# Lane Cove Bushland & Conservation Society Inc

10<sup>th</sup> May 2019

## **Submission from the Lane Cove Bushland and Conservation Society to SSD 9741, Proposed Data Centre, 1 Sirius Road, Lane Cove West**

- STORMWATER PIT
REFER DWG DAC402 FOR DETAILS
ALL SURFACE INLET PITS TO BE INSTALLED
WITH SW360 ENVIROPOD UNO
- STORMWATER PIPE
REFER DWG DAC402 FOR DETAILS
- DOWNPIPE CONNECTION (INGROUND)
- DOWNPIPE CONNECTION (SUSPENDED)
- ROCK HEADWALL WITH SCOUR PROTECTION
REFER TO DAC402 FOR DETAILS

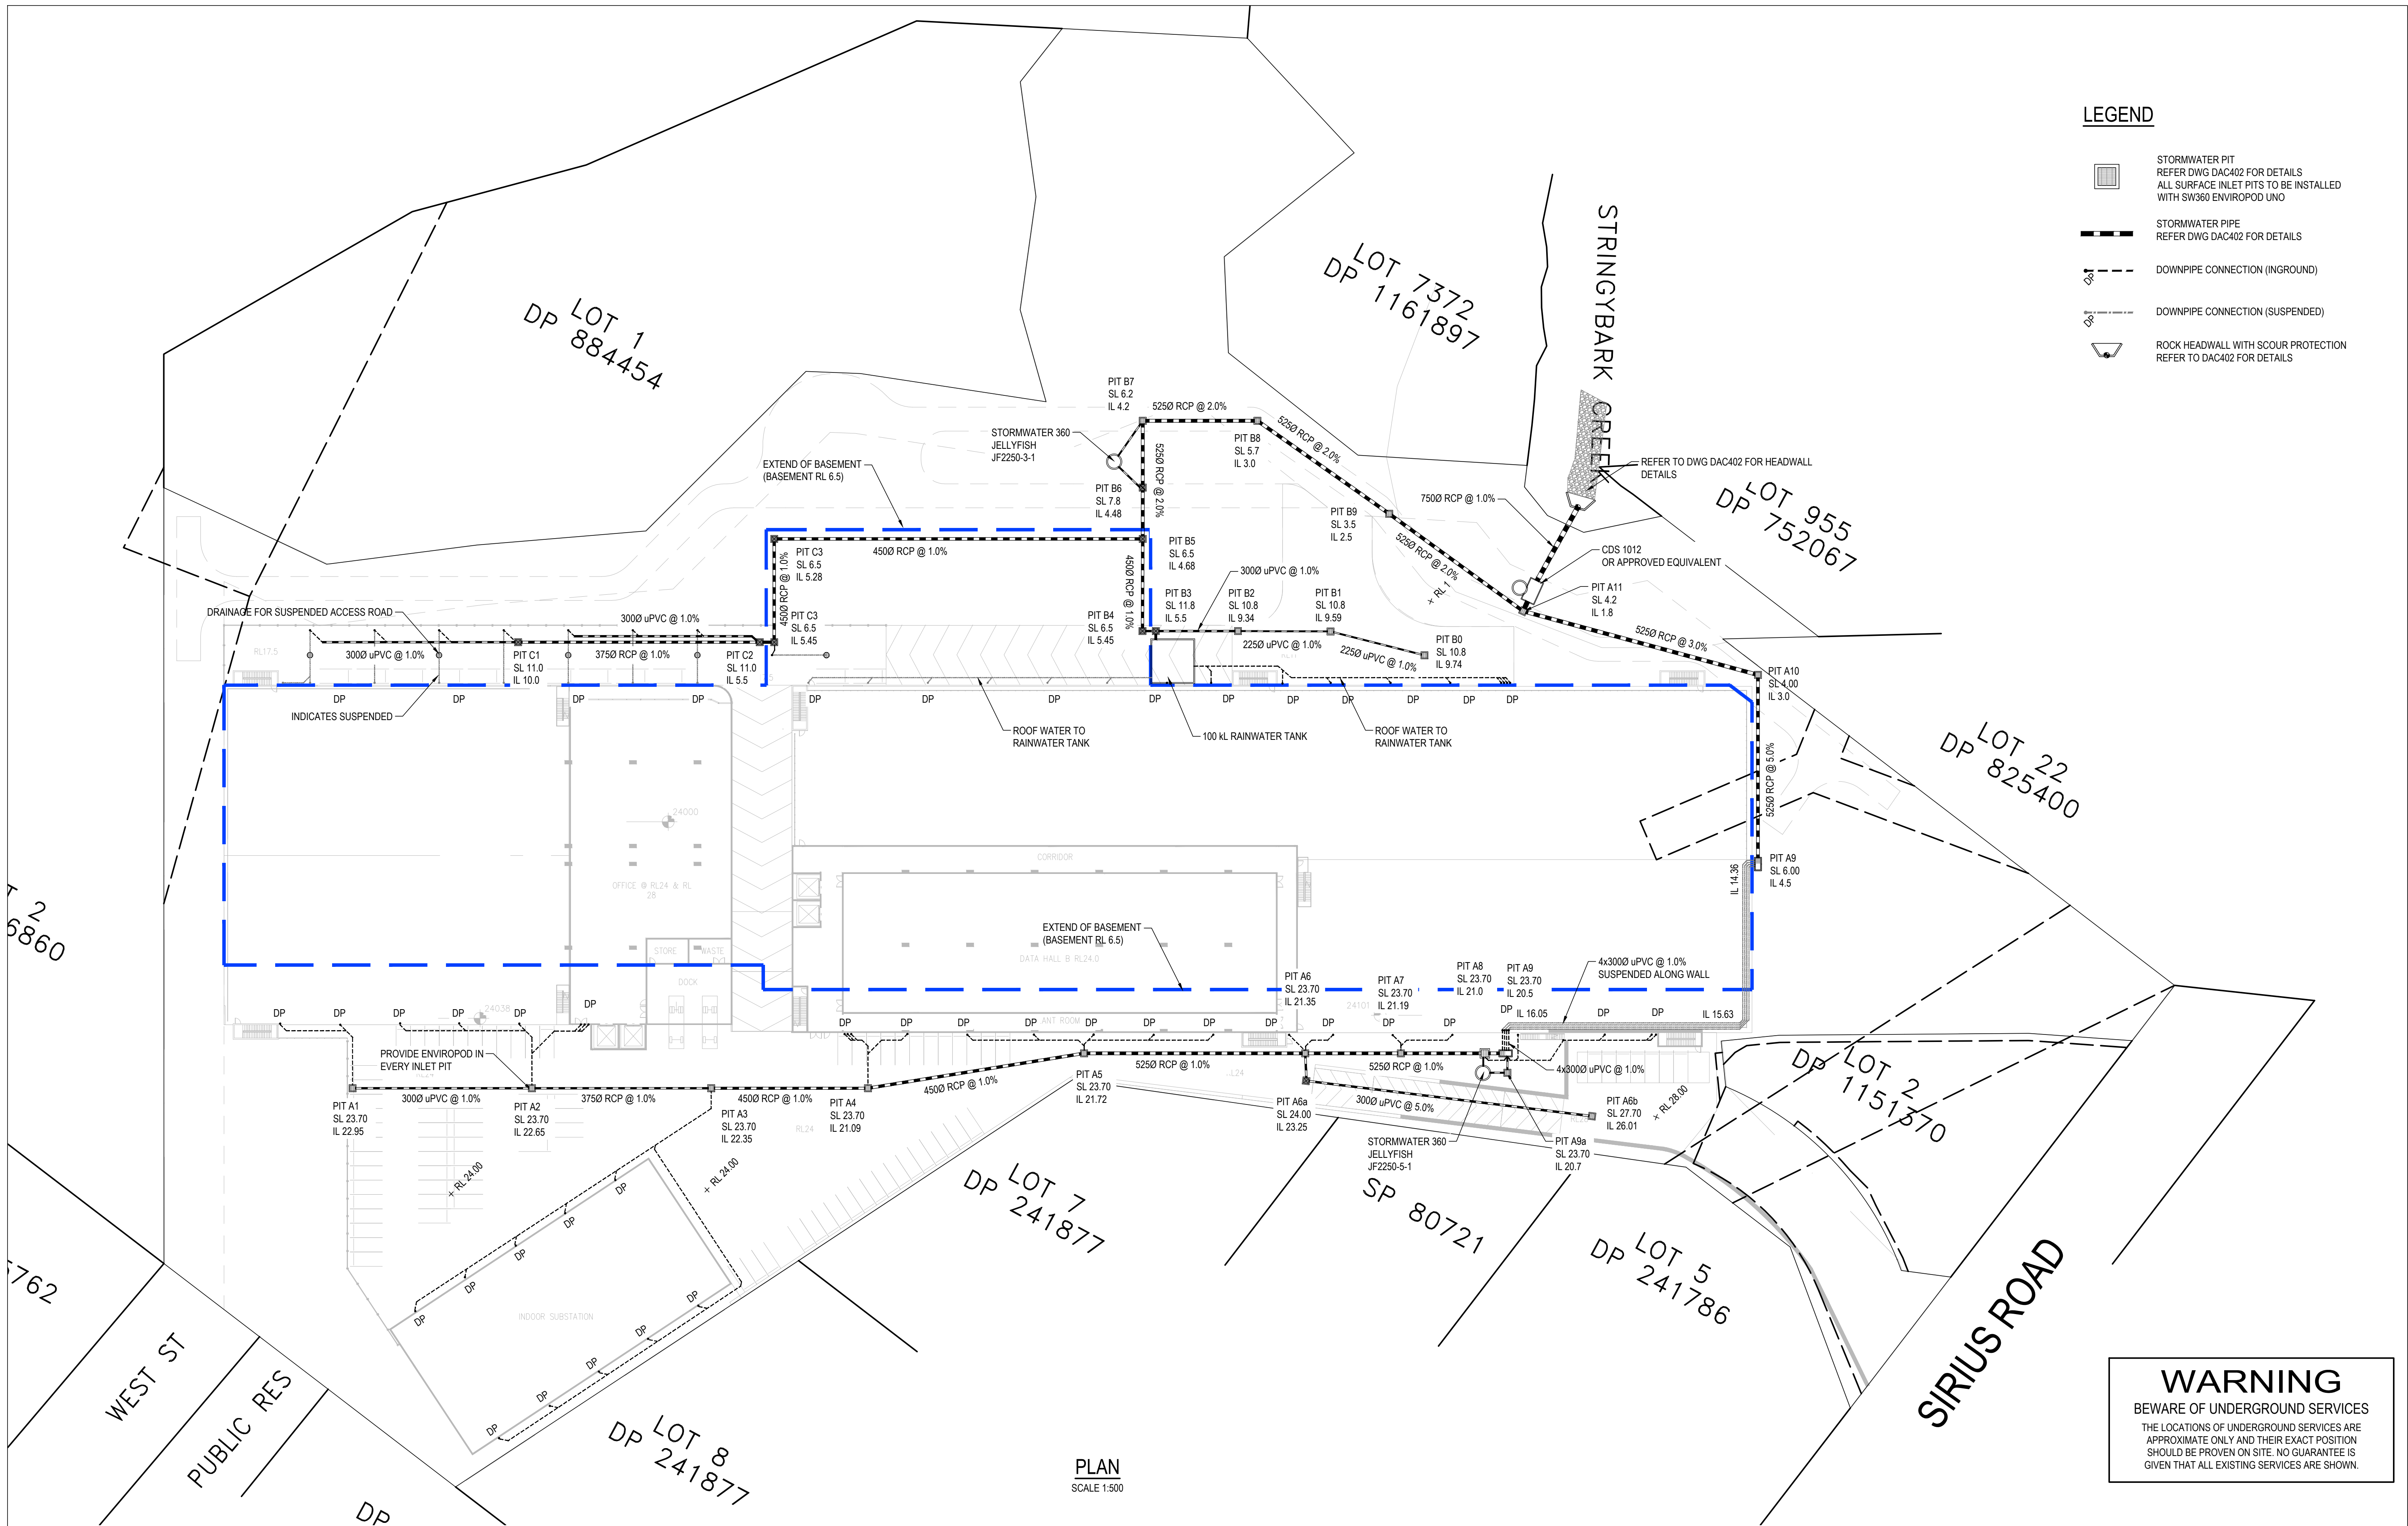
At the moment some rain falling on the site drains to the south and southwest feeding the wetland areas in Ventemans Reach Reserve. This must be preserved with any development. Some stormwater should be directed to this end and controlled in its discharge by an OSD as well as subsurface drainage trenches so that the water is slowly released to the wetland and its vegetation.

Stormwater directed to the north and Stringybark Creek must also be controlled by OSD and dissipation so that there is no scouring of the creek with the rush of large volumes of water in times of heavy rain. This detention could also be used to supply more landscape water which will be necessary to maintain the large landscape areas.
